Following the SSD application for New Liverpool Primary School, we received Response to Submissions from DPIE. Please see below responses to comments:

RD1 - ROLLER DOOR METAL CANTEEN
RD2 - ROLLER DOOR METAL HALL
SH - METAL FRAMED SUN SHADING
SM - WINDOW SECURITY MESH

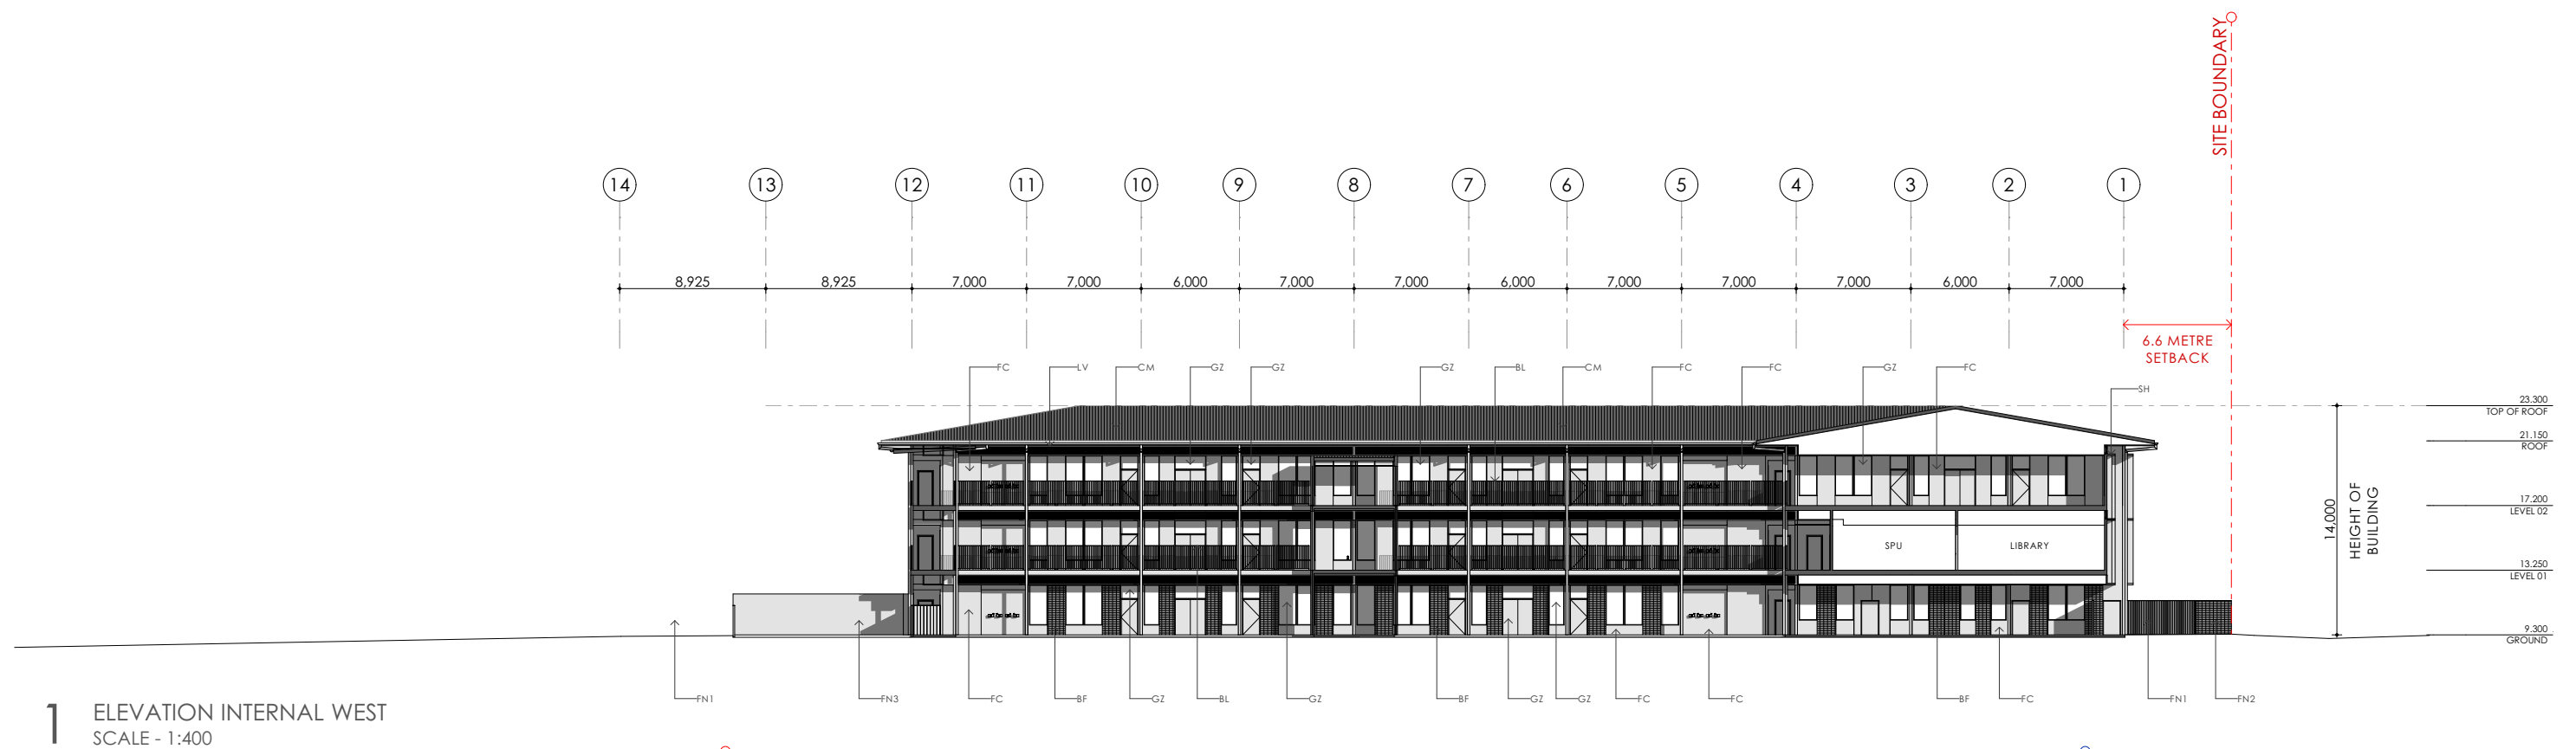
Government Architect NSW (GANSW) have reviewed the EIS and have raised concerns regarding the full height glazing to the Western façade with no shading and no planting able to be facilitated along the boundary. In recognition of the western elevation, you are requested to address this issue and provide additional shading devices or articulation of this façade which can result in shading.

500mm deep vertical and horizontal sunshades have been provided to the Western façade which work with the ratio of 30% performance glazing to 70% solid façade to achieve a compliant Solar Heat Gain Coefficient of 0.6. Mid-Summer shading studies on the Western Façade show how eaves horizontal projections mitigate midday sun into West facing spaces.
